**KIRKLEES METROPOLITAN COUNCIL
INVESTMENT & REGENERATION SERVICE**

DELEGATED DECISION TO DETERMINE PLANNING APPLICATIONS

Reference No:	2023/62/91795/E
Site Address:	2, Enfield Drive, Carlinghow, Batley, WF17 8DY
Description:	Erection of two storey side extension and new porch with associated alterations
Recommending Officer:	Nicole Helliwell

Officer Report

Drawing Title
 PROPOSED

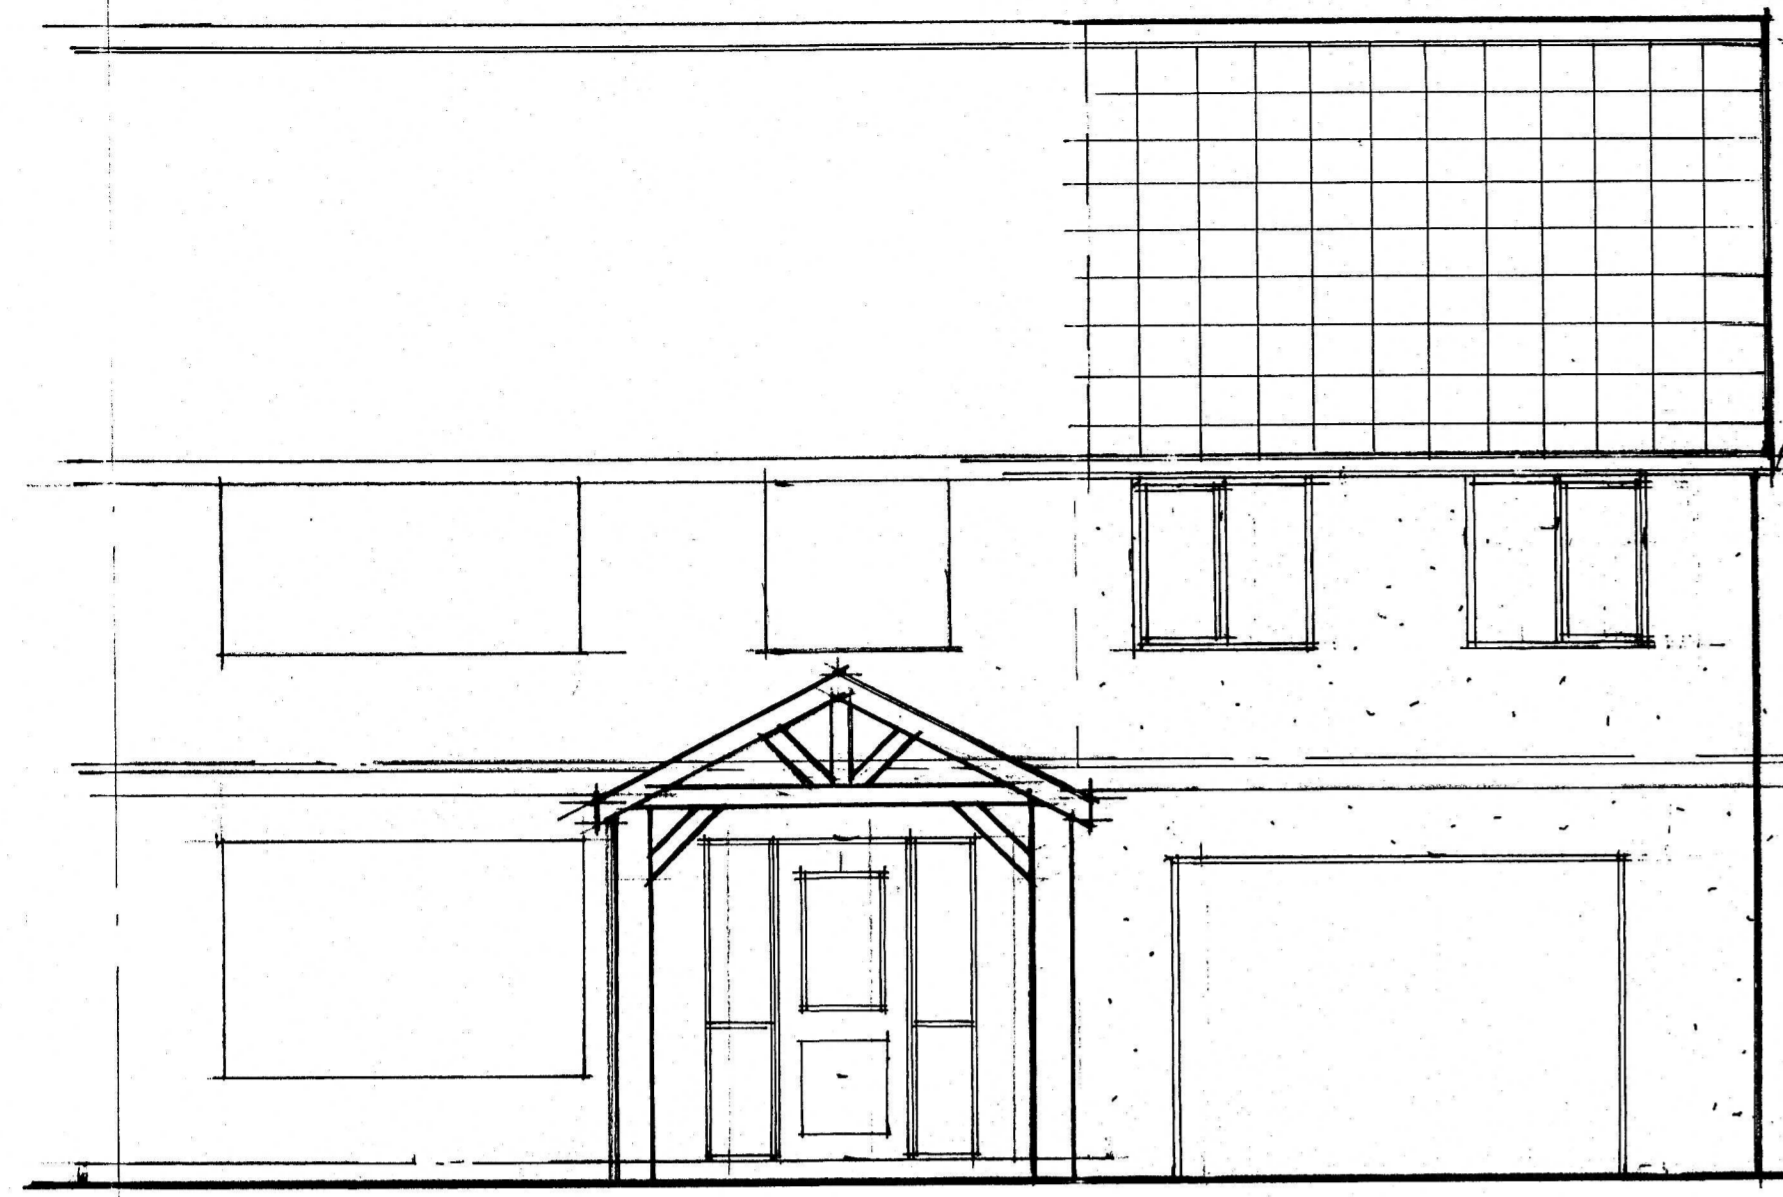
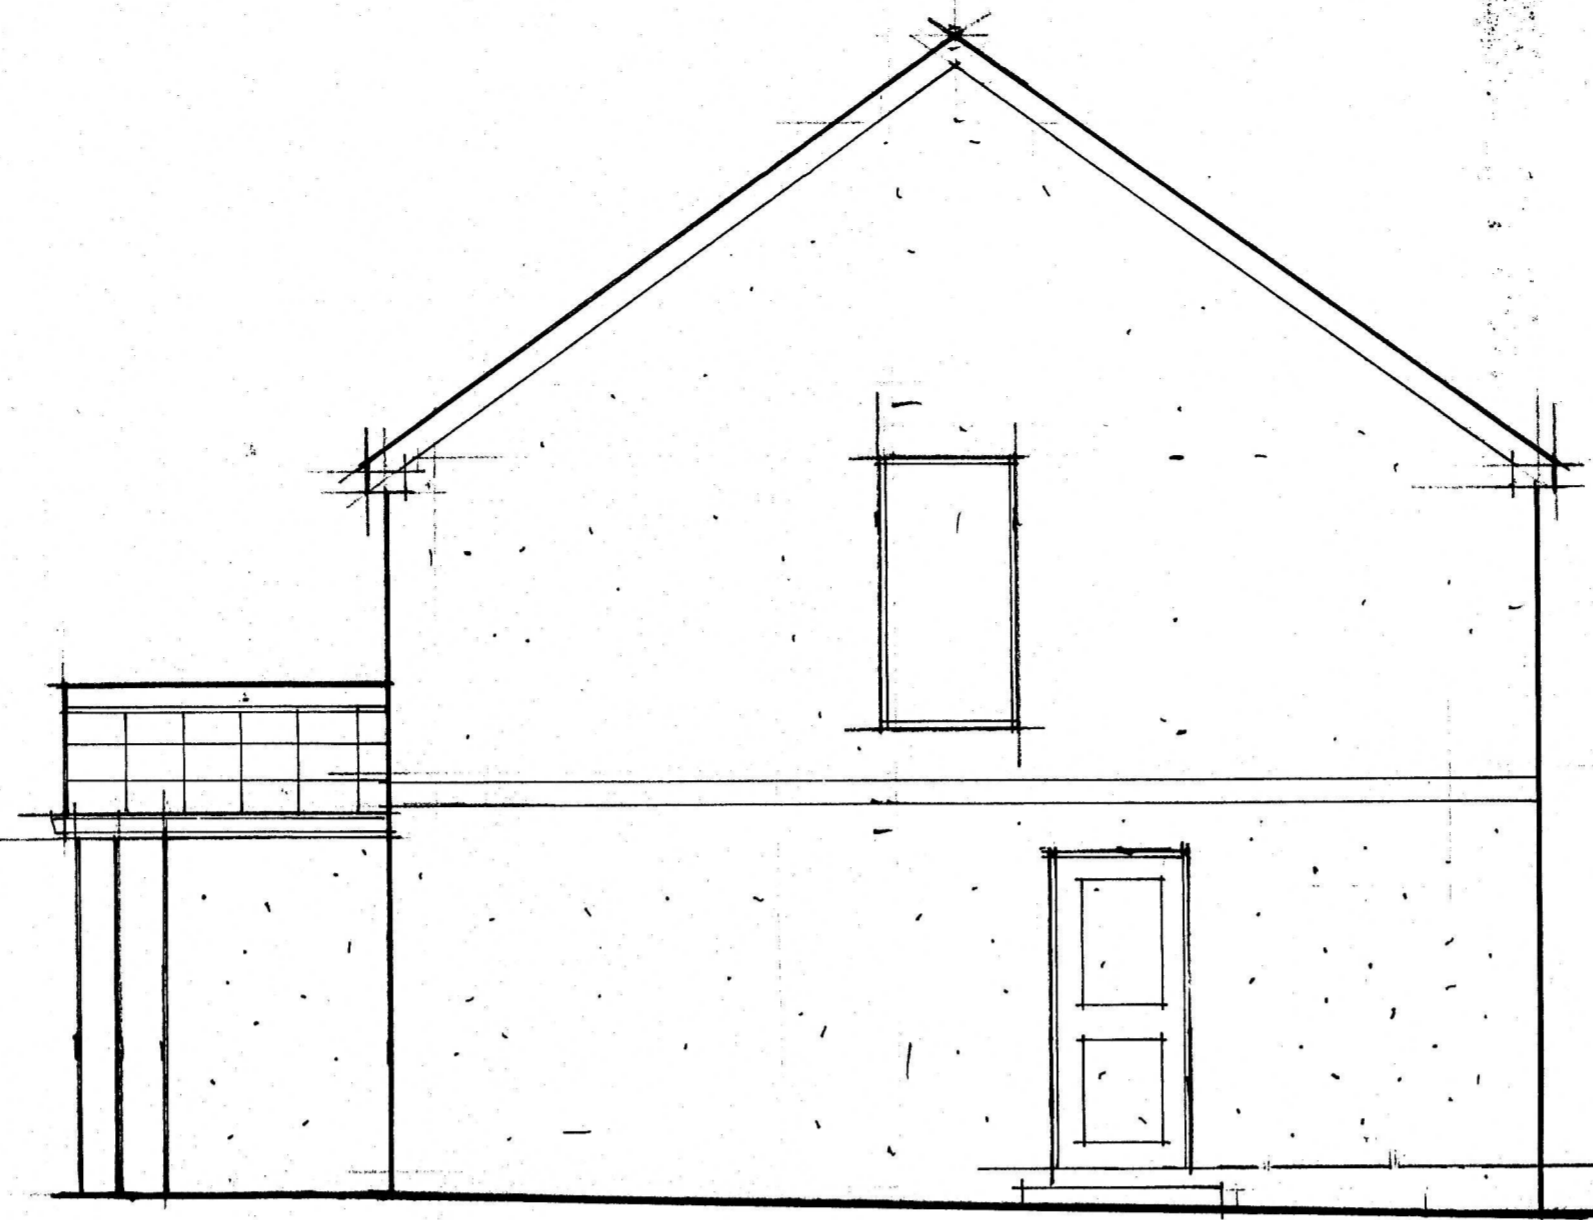
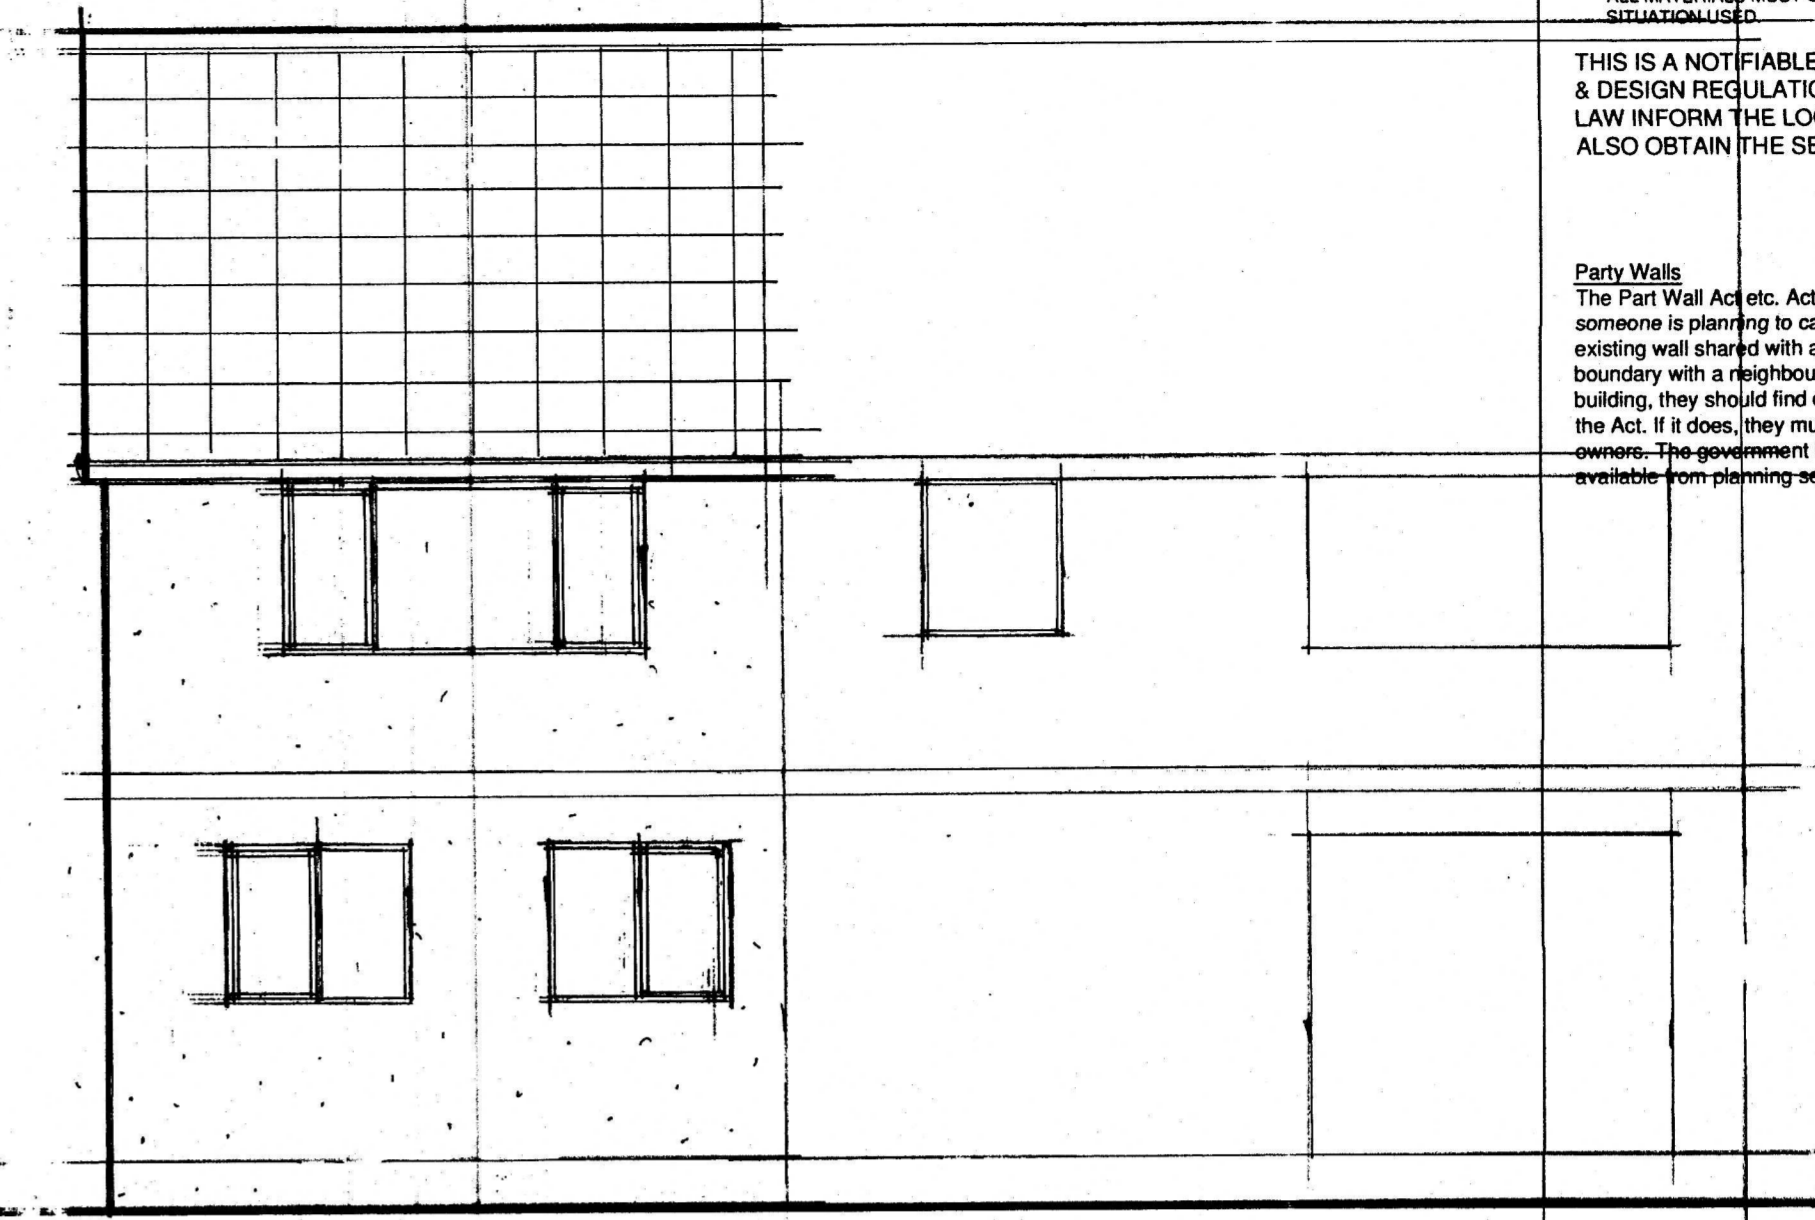
The proposed two storey extension would project approximately 4.5m from the side elevation of the original dwellinghouse. The enlargement would be faced in pebble dashed render and would incorporate a dual pitched roof finished in concrete tiles to match the appearance of the host property. Although the extension would be flush with the principal elevation and would feature a comparable ridge line to that of the host dwelling, given that the property occupies an end plot of an ample size, the extension would maintain a sense of space and would appear subservient in relation to the host property. Whilst it is noted that the enlargement would alter the scale and form of the original build, it would not represent an incongruous or unduly prominent feature or amount to overdevelopment. Furthermore, the plans confirm that the extension would retain at least a 1m gap to all property boundaries and would not give rise to any terracing effect. Therefore, it is considered that on balance, in this instance, the proposal would not have

The proposed canopy would extend approximately 0.6m from the front elevation of the proposed porch extension. Whilst it is acknowledged that front canopies are not a common feature within the street scene, it is noted that the structure would have a modest scale and would appear subservient to the original build. Furthermore, the canopy would be set back from the pavement and would not appear overly prominent from public vantage points. Therefore, it is considered that the proposed development would be acceptable in terms of visual amenity.

4 Enfield Drive is a residential property located west of the application site. The submitted plans confirm that the proposed front porch would be positioned approximately 3m away from the common boundary shared with no.4 and would accord with the 45-degree rule in relation to the neighbour's ground floor fenestration. Furthermore, the proposed two storey side extension would be positioned east of the host property and would not project forward of the neighbour's front or rear elevations. Therefore, due to its siting, it is considered that there would be no undue harm to the neighbouring occupants with regard to overlooking, overshadowing and overbearing impact.

Amendments were sought during the course of the application. A request was made to reduce the projection of the proposed two storey side extension, set it down from the existing ridge line and back from principal elevation in line with the House Extensions and Alterations SPD. Although the revised drawings submitted did not address all of the concerns raised, the agent did provide full justification as to why the proposed development would be acceptable. Therefore, on balance it is considered that the design of the proposed two storey extension would be appropriate from a visual amenity perspective (this is expanded upon in the visual amenity section of the report).
